Engineers Comments Regarding Surface Water Drainage

Application Reference:	BE/29/25/DOC	Reviewer Reference:	ADC/SB
Planning Officer:	Emma Sheppard	Date of Review:	05/06/2025
Site Name:	Land at Oldlands Farm Newlands Road Bognor Regis PO22 9NN		
Application Description:	Approval of details reserved by condition imposed under reference BE/150/22/OUT relating to condition number 23 - discharge to a watercourse or culvert.		
Assessment Number:	1 of 2

Drawn:	J.Arnold	Reviewed:	T.Jones
BWB Ref:	243912	Date:	08.11.24
Scale@A1:	1:500		
FOR COMMENT			
Project - Originator - Zone - Level - Type - Role - Number	Status	Rev	
243912-BWB-EXT-XX-D-C-0500	S3	P01

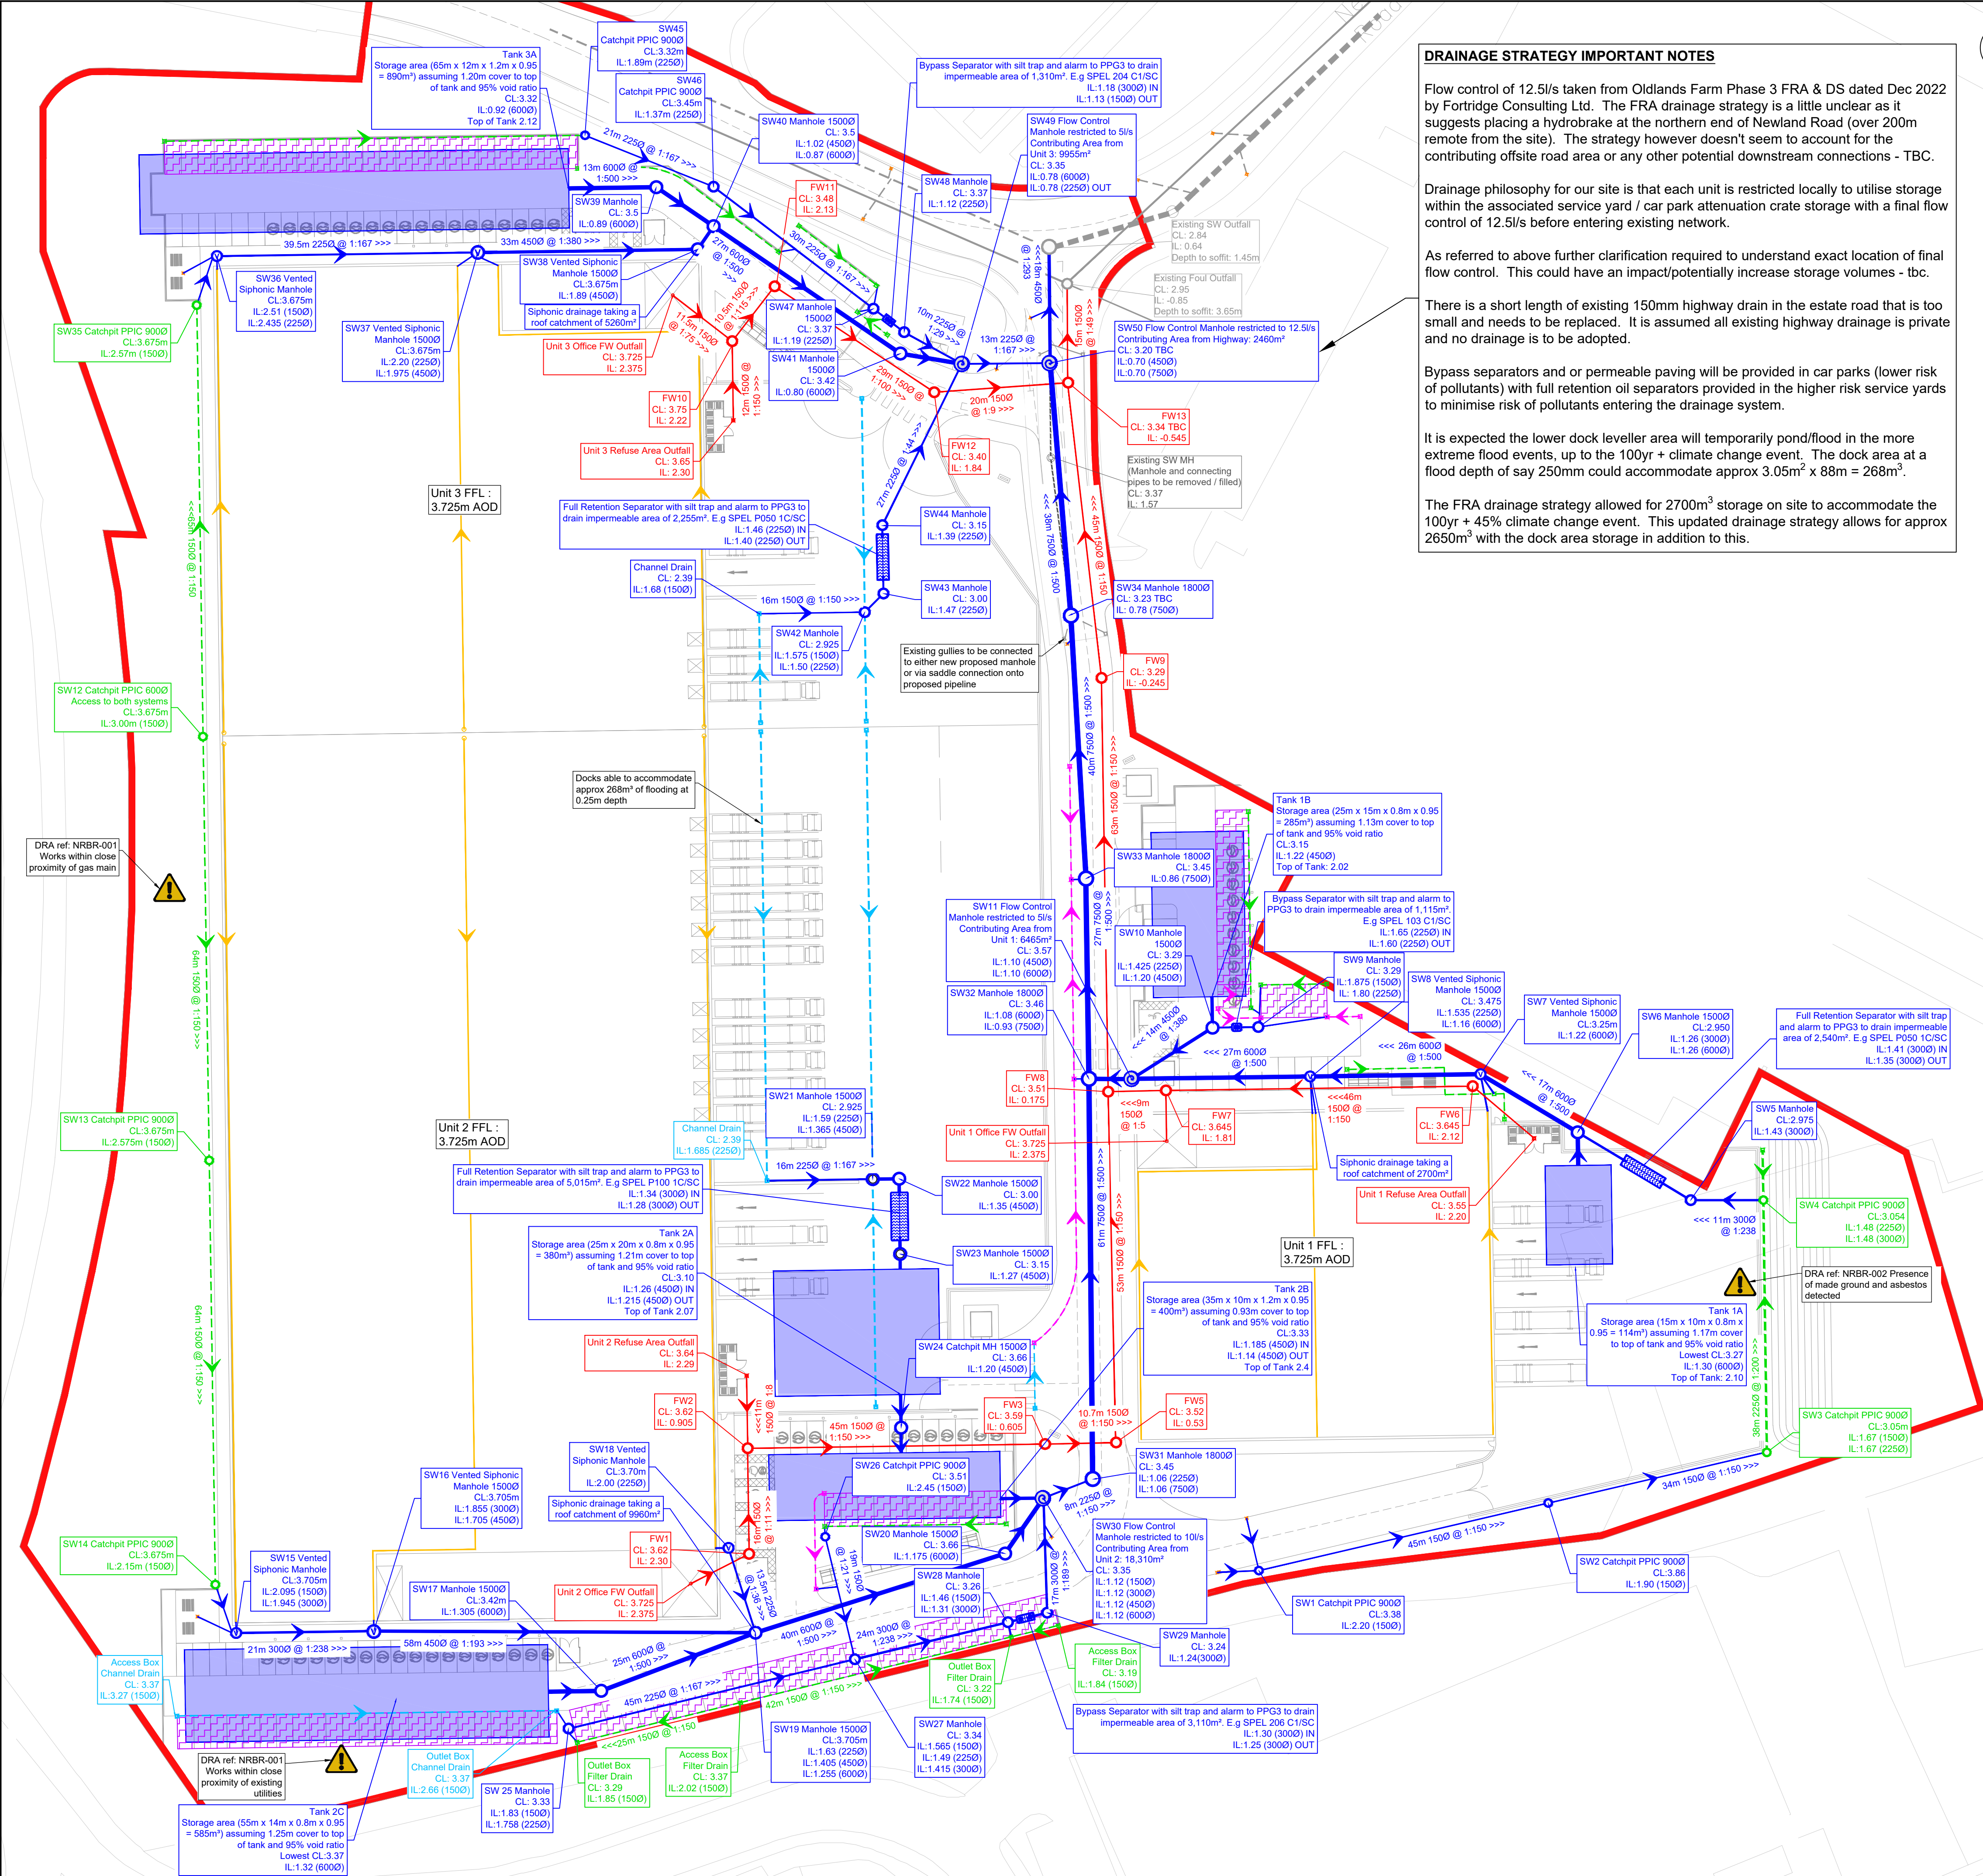
The reserved matters relating to the planning permission reference BE/150/22/OUT have not been approved. The surface water drainage design associated with what will be the approved reserved matters has not been approved. No specific details regarding proposals to discharge to watercourses associated with the approved design, as required by this condition have been submitted. It is therefore not possible to accurately assess or support this application.

It is suggested that the designer approaches WSCC and our land drainage team to determine what consents (ordinary watercourse land drainage consent, or land drainage byelaw consent) are required to permit any proposed connections or alterations to watercourses. The approvals and approved plans should then be submitted to support and application to discharge this condition.
